From: Sue Howell
Sent: 31 July 2017 17:04
To: Planning.Responses
Cc: Anita Gardner
Subject: RE: Planning Consultation on F/17/17/DOC

Comment from Greenspace

APPLICATION NO: F/17/17/DOC

Works: condition imposed under previous planning permission F/15/16/PL relating to condition No. 3 (SUDs system), 4 (Landscaping Scheme) & 10 (Construction site set up)

Drg. No. 2017/1/8

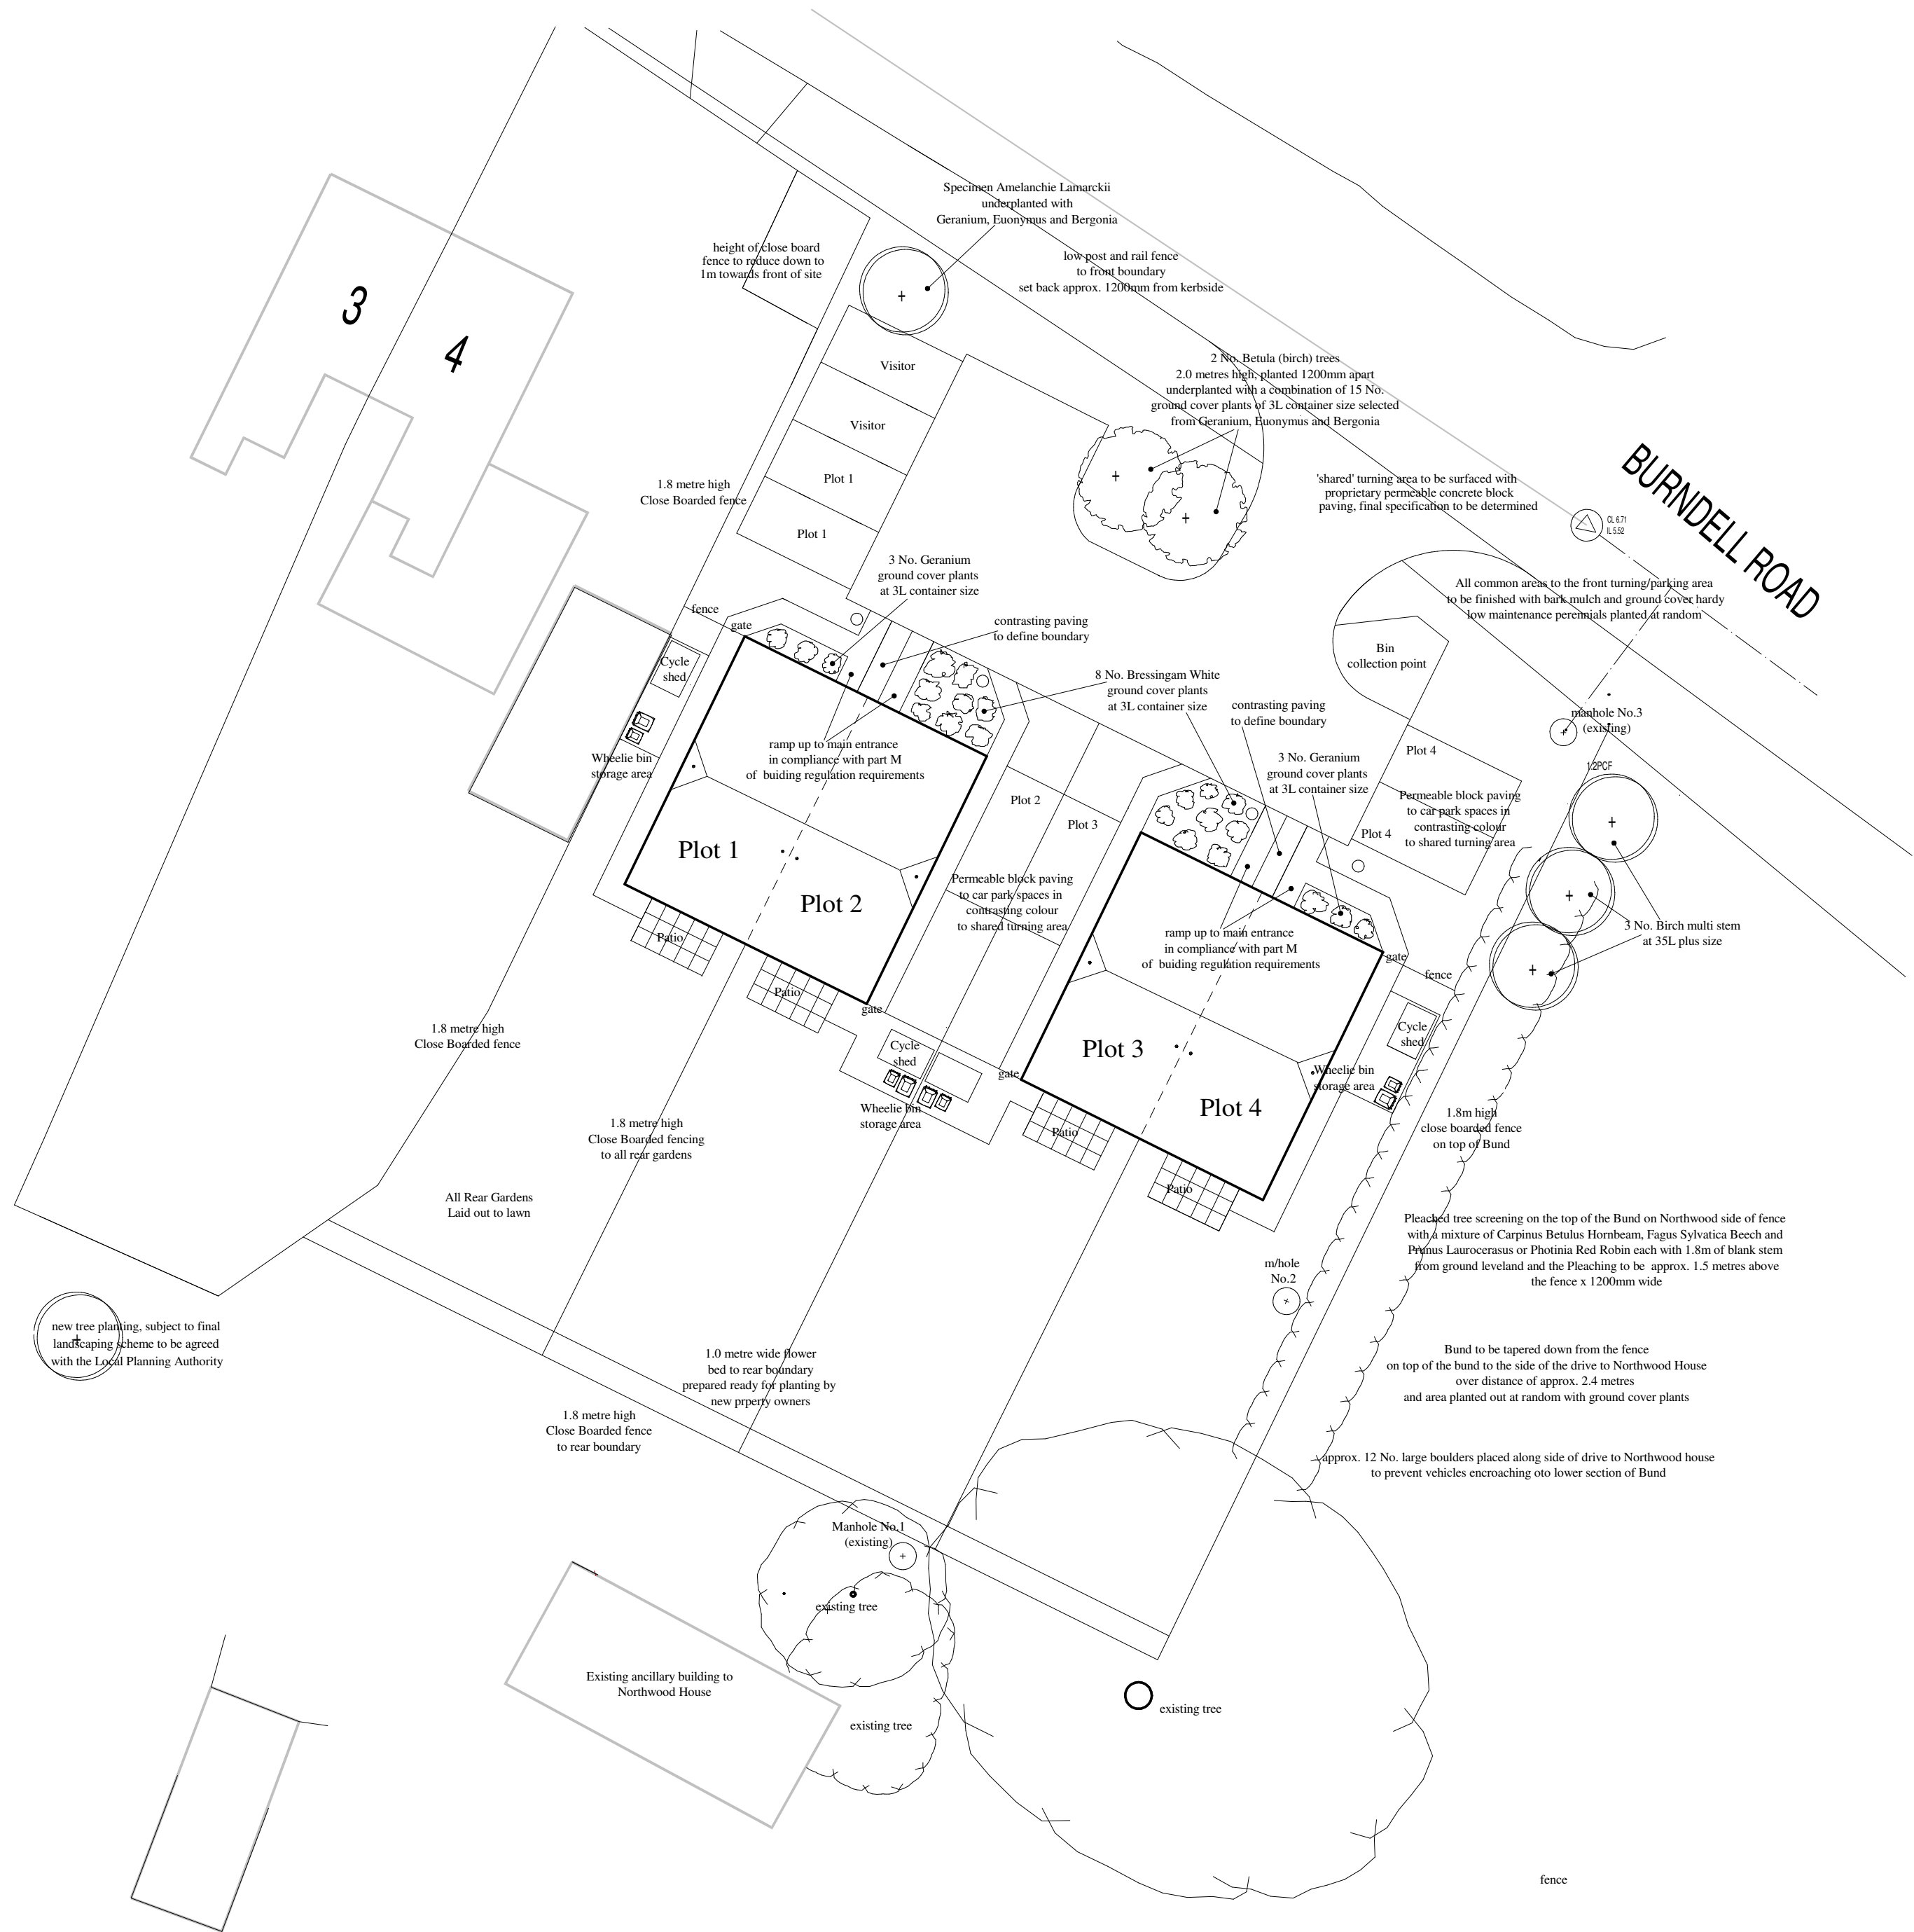
Further to submission of drawings no 2017/1/8 landscape Proposals, we confirm that the information supplied does propose a landscaping scheme which would be fitting for location and therefore we would **recommend the discharge of Condition 4 Landscaping imposed under planning approval F/16/16/PL on this application F/17/17DOC.**
